PAQUETTE PLANNING ASSOCIATES LTD.
URBAN PLANNING AND LAND DEVELOPMENT CONSULTANTS

Re: Zoning By-law Amendment D02-02-21-0008 and Site Plan Control D07-12-21-0015
120 Den Hagg Drive
Phase 1

Circulation Comments and Responses

DRAWING TITLE:  
LANDSCAPE PLAN

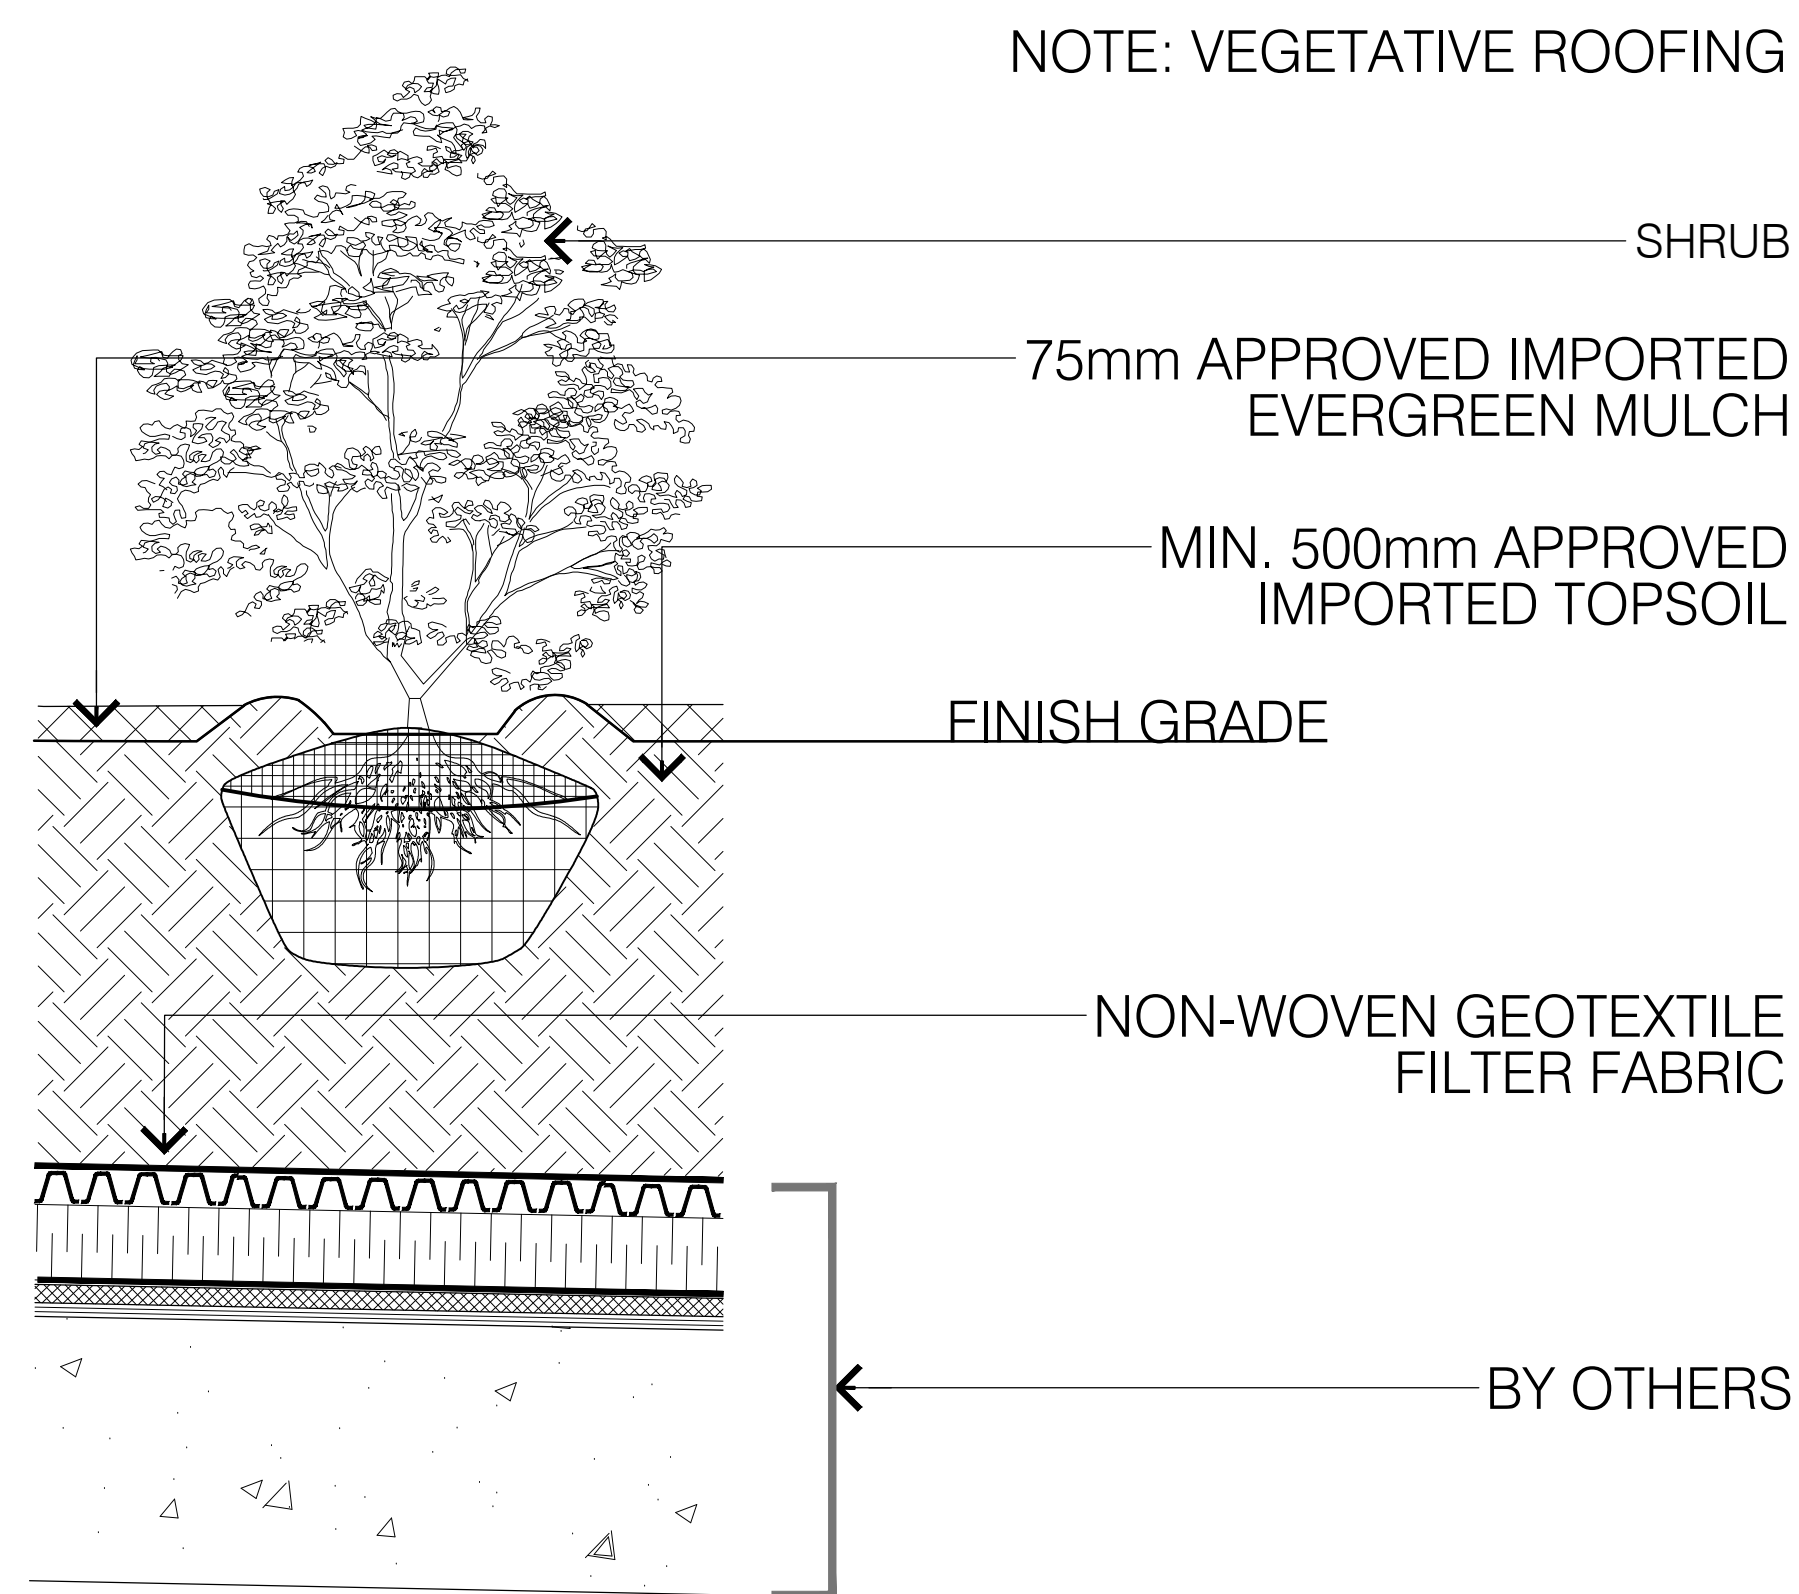
4. On the landscape plan, please consider re-arranging soft landscape vs hard surface at the south-west corner of the building outside of the hydro room . Minimize hard surface, and if possible, connect the hard surface with entrance to the garage and use soft landscaping to screen the hydro room doors (also see attached image below).

4.a• The Panel recommends curving or terracing the retaining wall and using stone materials to create a distinct element that will be part of the landscape rather than an extension of the building. Furthermore, the Panel recommends the use of evergreen shrubs that are suited for Ottawa's climate and will provide year-round greenery.

Response: Hydro Ottawa requires direct access to hydro vault. Current path allows for access and additional clearance pathway (1100mm) for exiting.

Response: Noted. Retaining wall has been adjusted and segmented for smoother transition.

SOUTH ELEVATION
1:150

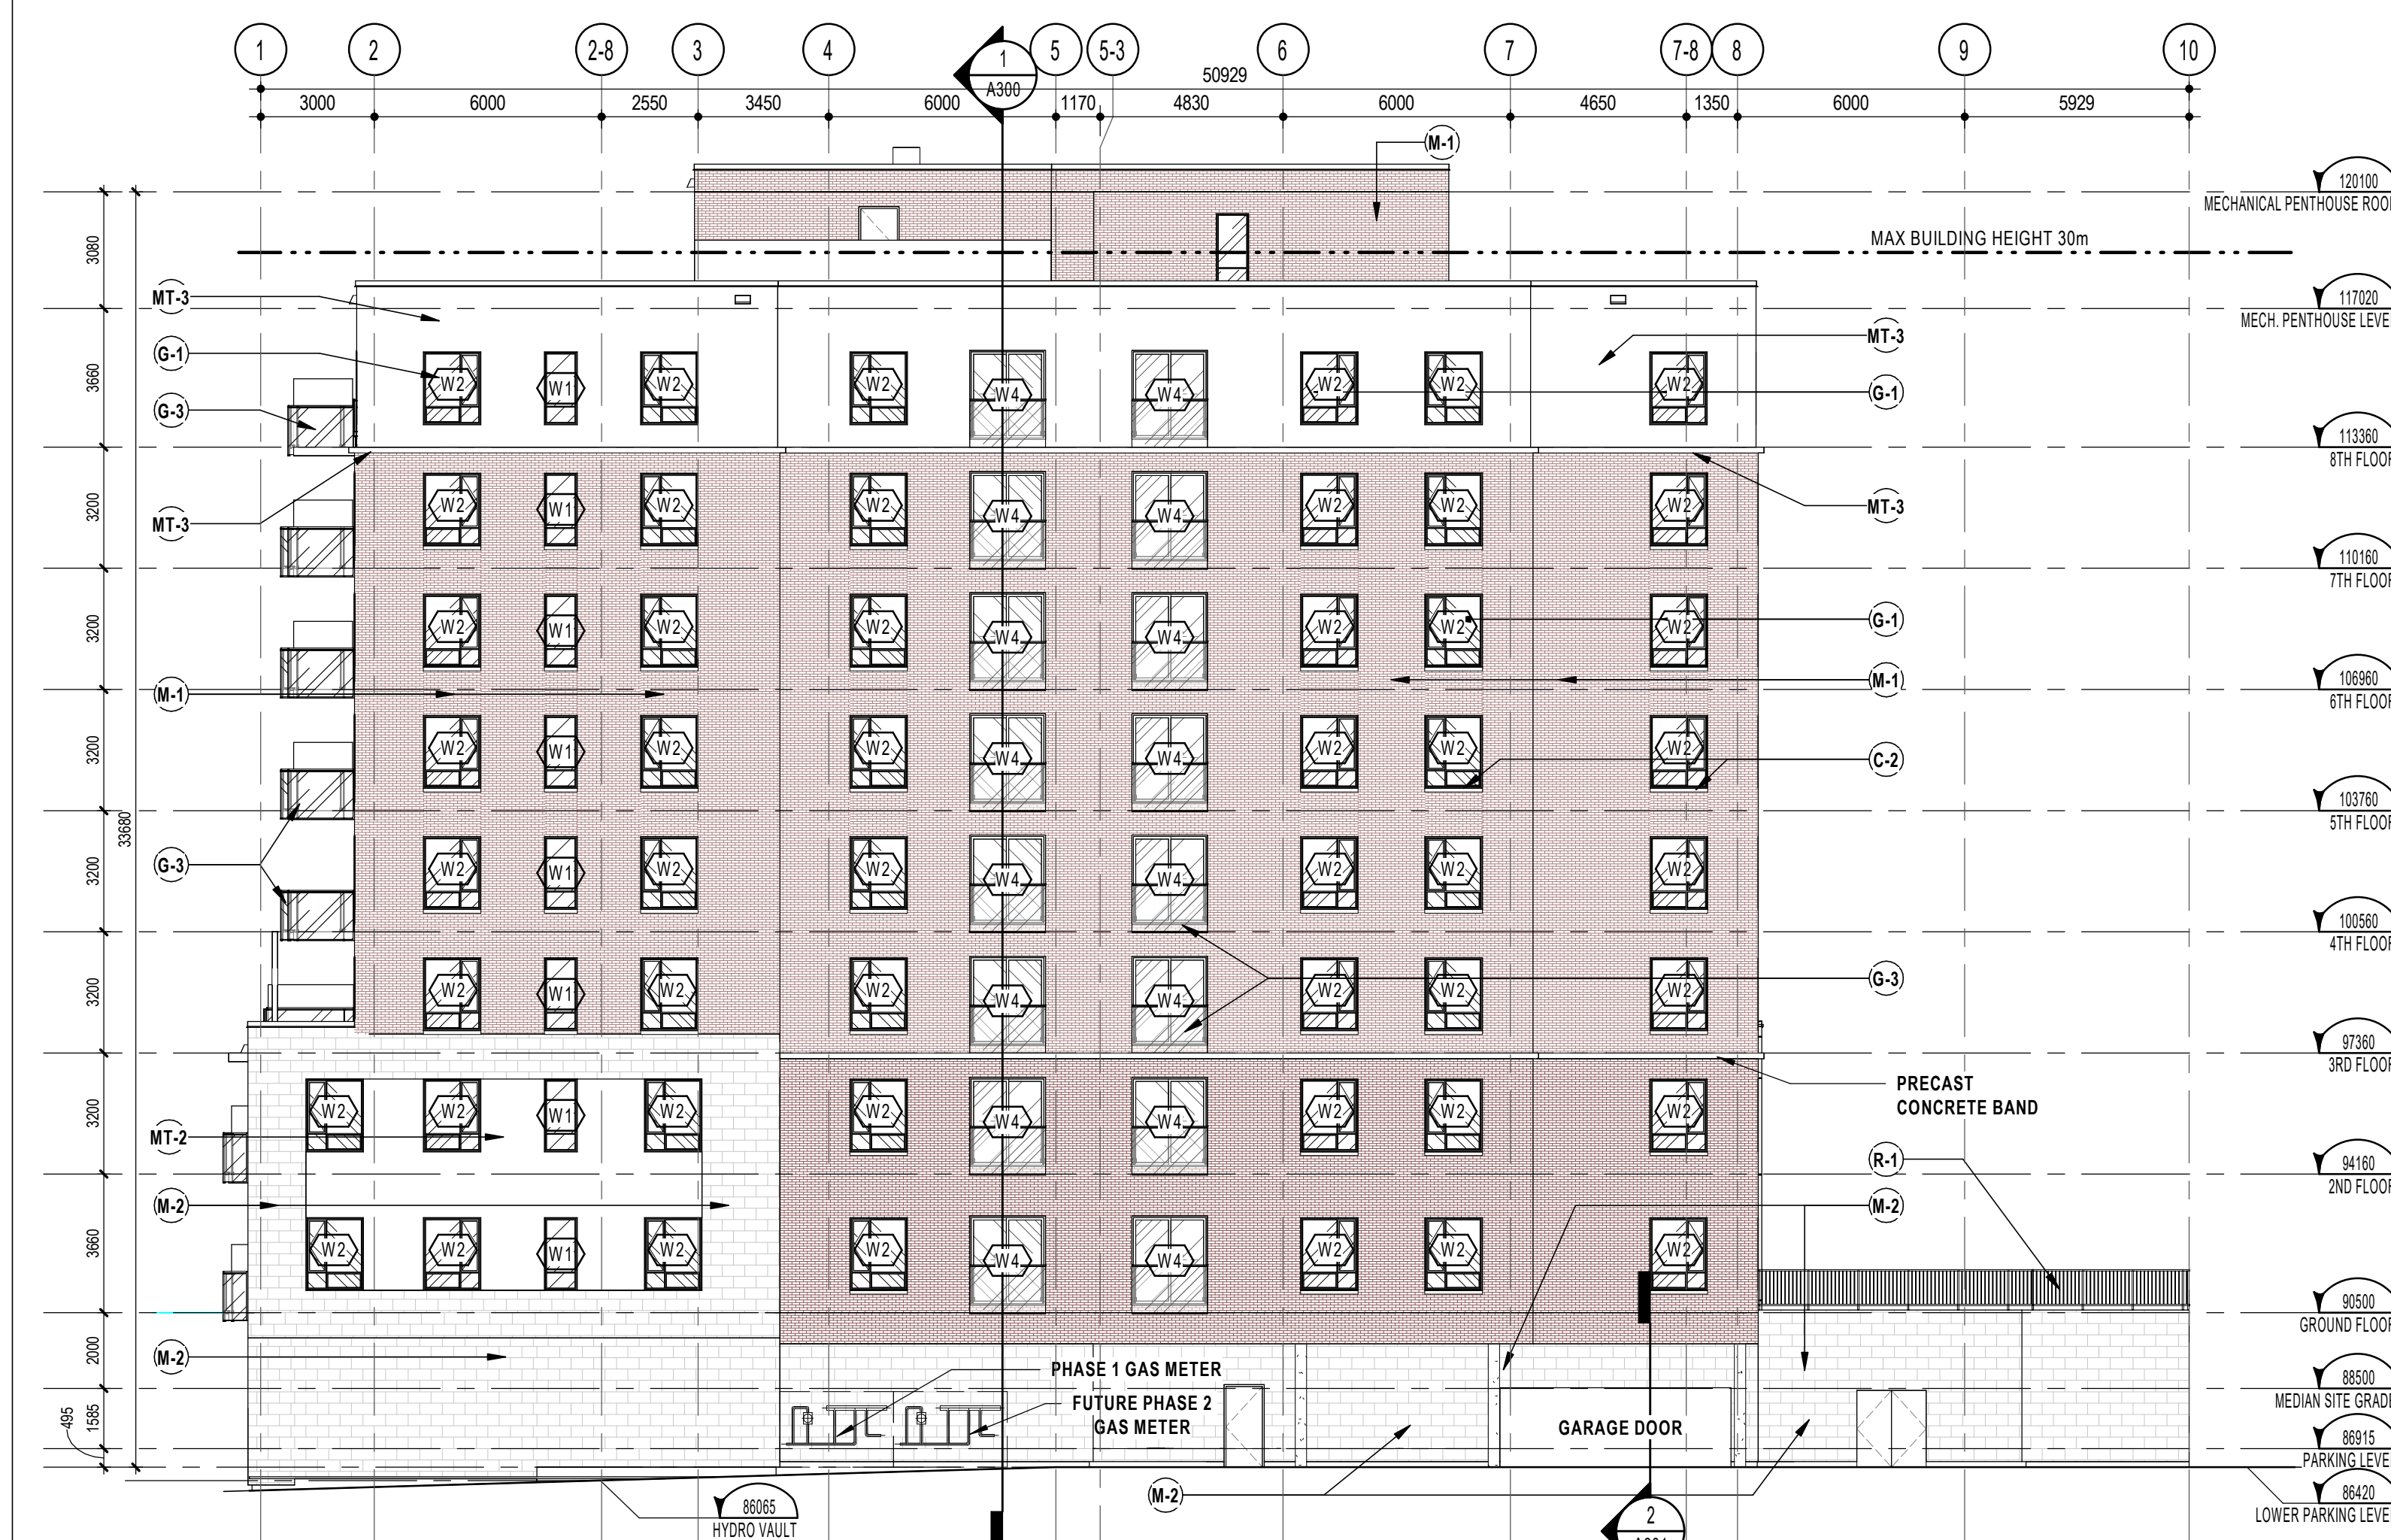
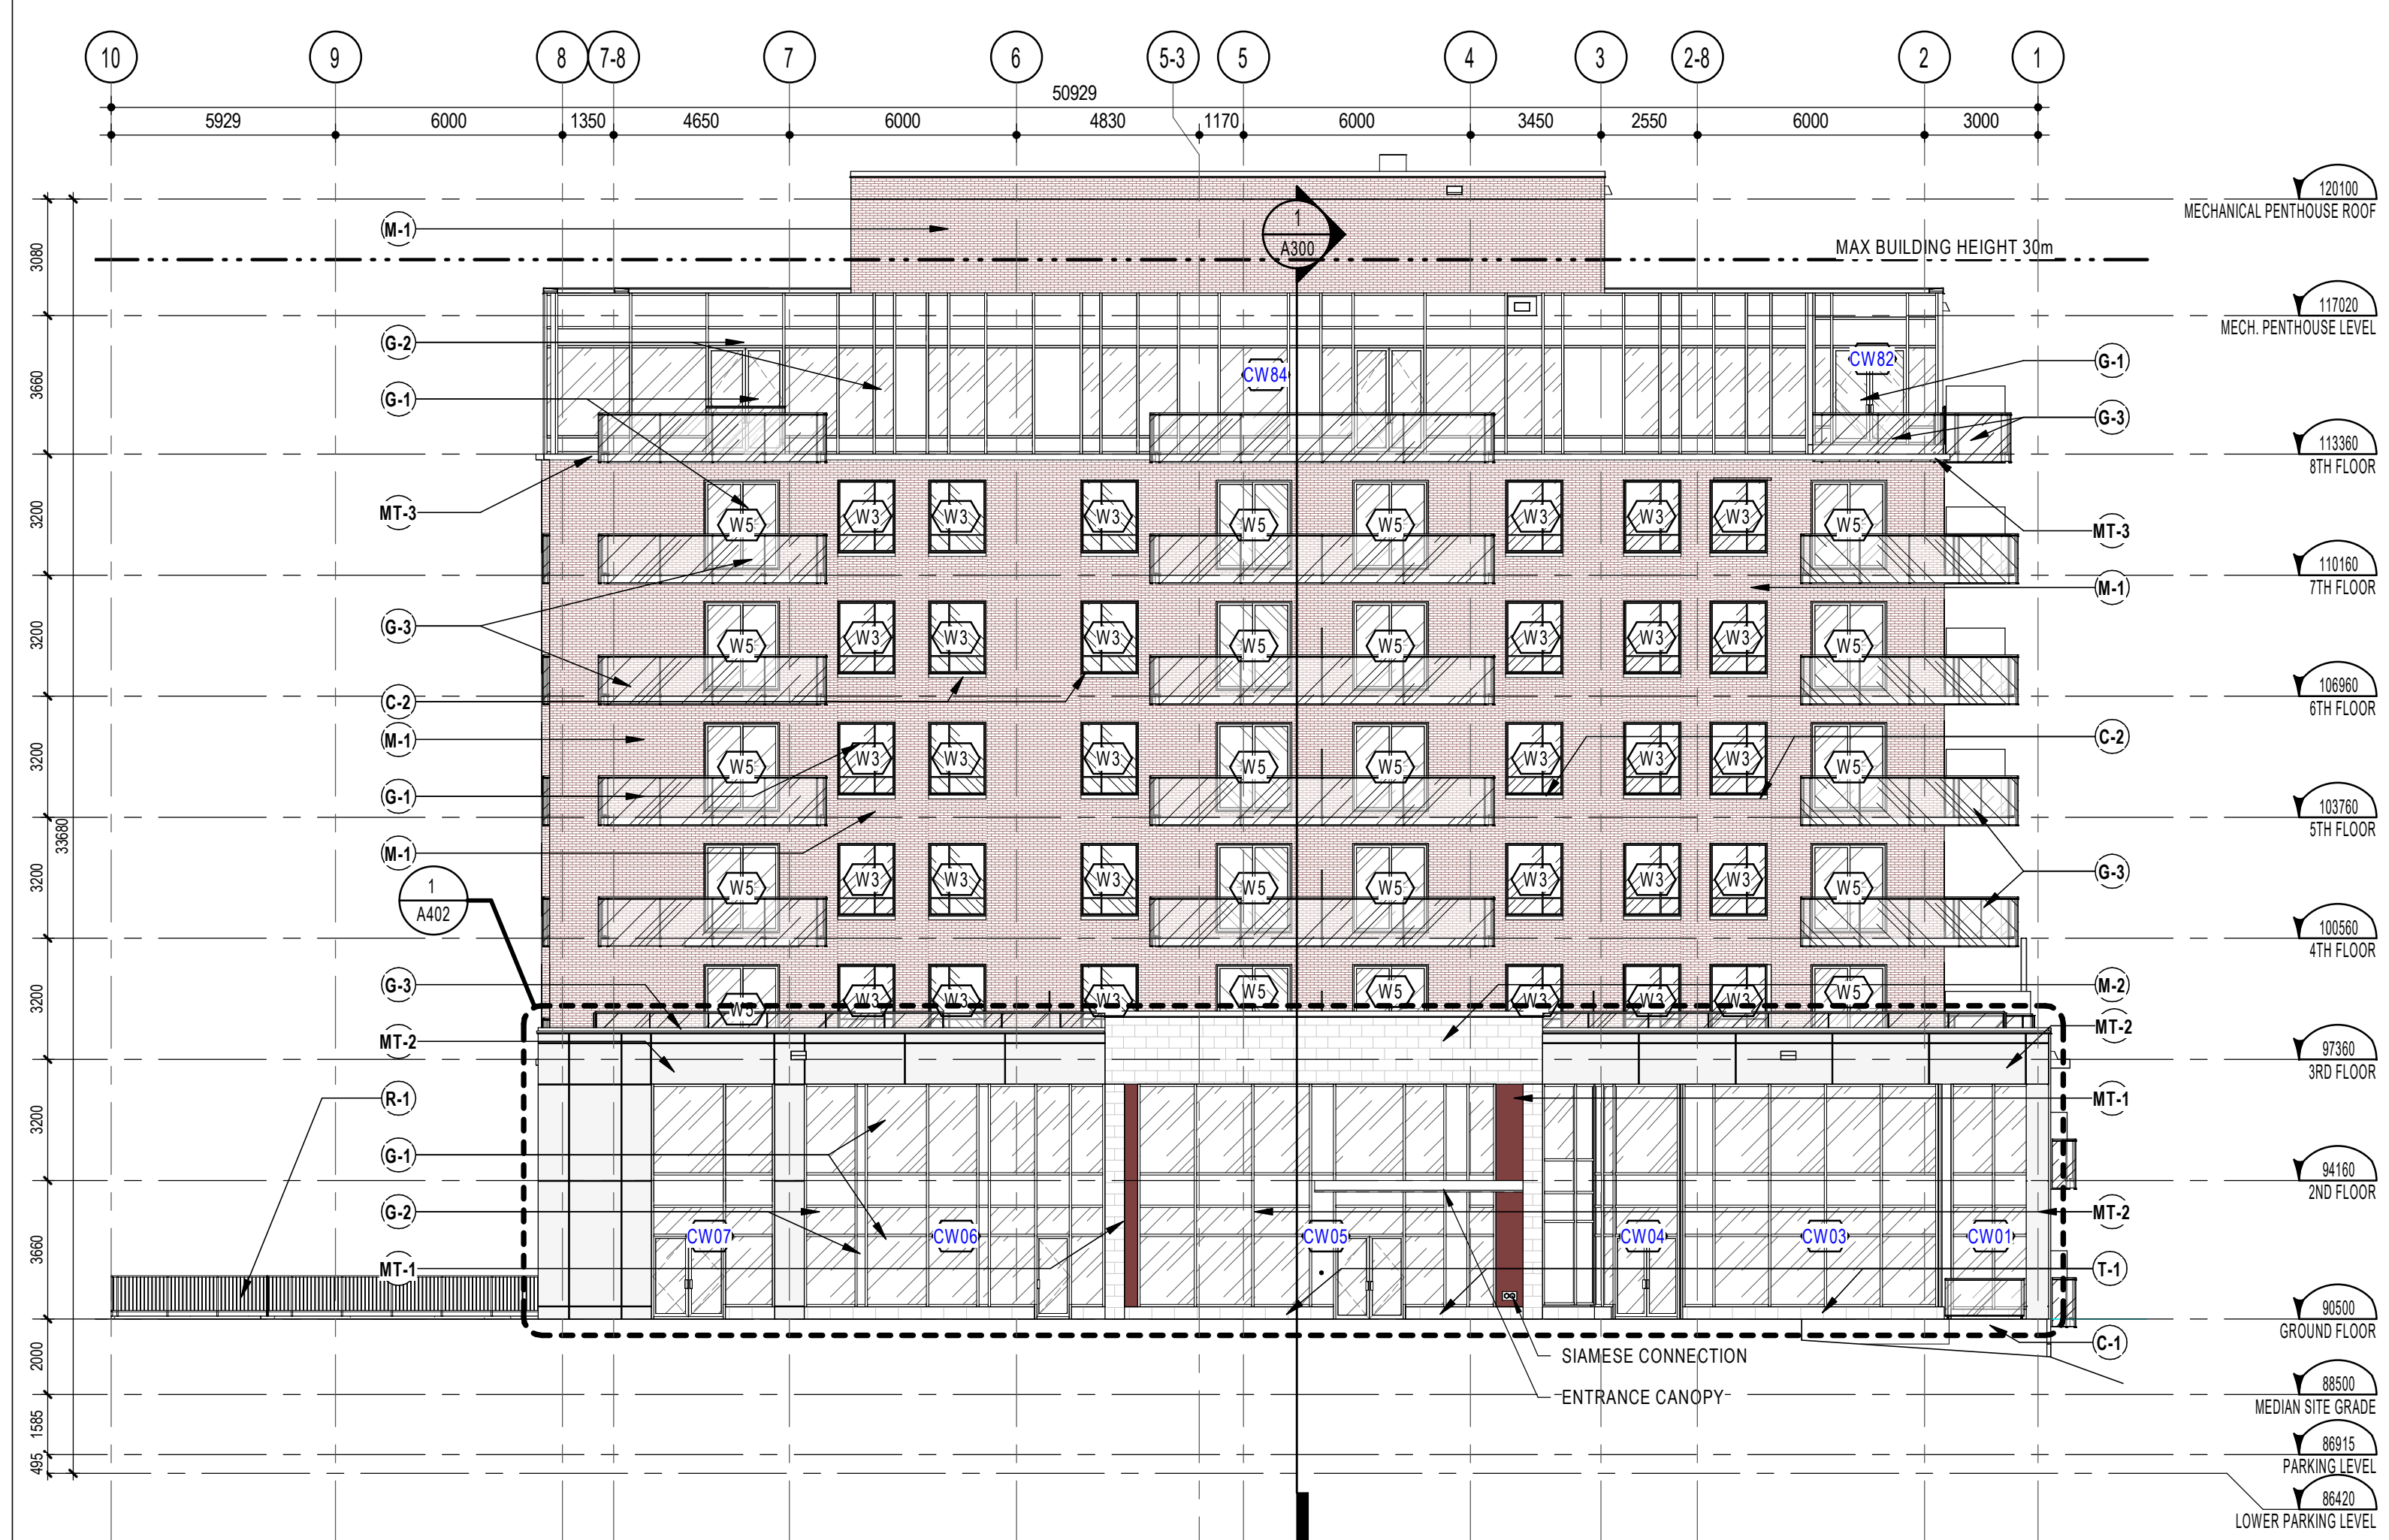
2.a• The Panel has concerns with the street facing projected balconies, especially at the corner, making the building feel top-heavy. The proponent should consider in-setting the balconies at the corner and explore recessing or integrating all of the street facing balconies to strengthen the project as a street wall building.

2.c• The Panel recommends further refinement of the façade by removing the columns at the corner and creating a cantilever expression to simplify the base.

3.a• The Panel believes the building should be simplified as the base and top have different patterns of glazing and mullions, making the top appear taller.

3.b• The contrast of dark masonry at the base with the red brick middle portion needs further study. The changes in materiality appear co-planar, and the dark brick

between the windows does not successfully add depth or articulation.

3.c• The proponent should consider using contrasting colours to make the top lighter, establish a clear and consistent datum line where the material changes to glass and simplify the two-storey base.

3.d• The Panel appreciates the use of red brick and cautions that the white metal that currently extends to grade will be difficult to maintain; a material with greater durability and permanence (such as stone or precast) may be considered.

Response: Balconies revised to add more interest to the corner. 8th floor corner unit is recessed separating building top from middle. The light steel framing system chosen has limitations. The light steel frame requires a simplified load distribution from roof to foundation. Embedding balconies would interfere with loads and create additional structural elements.

Response: Removing Column at the corner and cantilevering the 3rd floor would cause structural concerns. Reducing the cantilever would affect the base, middle, top separations.

Response: Noted. Mullions and glazing spacing has been revised to project elements from the middle of the building into the 8th floor, and ground floors.

Response: Dark masonry removed from between windows. Masonry detailing between windows have been added to break up façade and allow for some differentiation, and interest between windows.

Response: 8th floor has been revised to a lighter colour. A datum line complete with architectural masonry element has been included at the 2nd floor added to separate a darker red back from a lighter red middle. Clearly separating base, middle, and top separations.

Response: Noted. Limestone base at all grade are provided for durability.
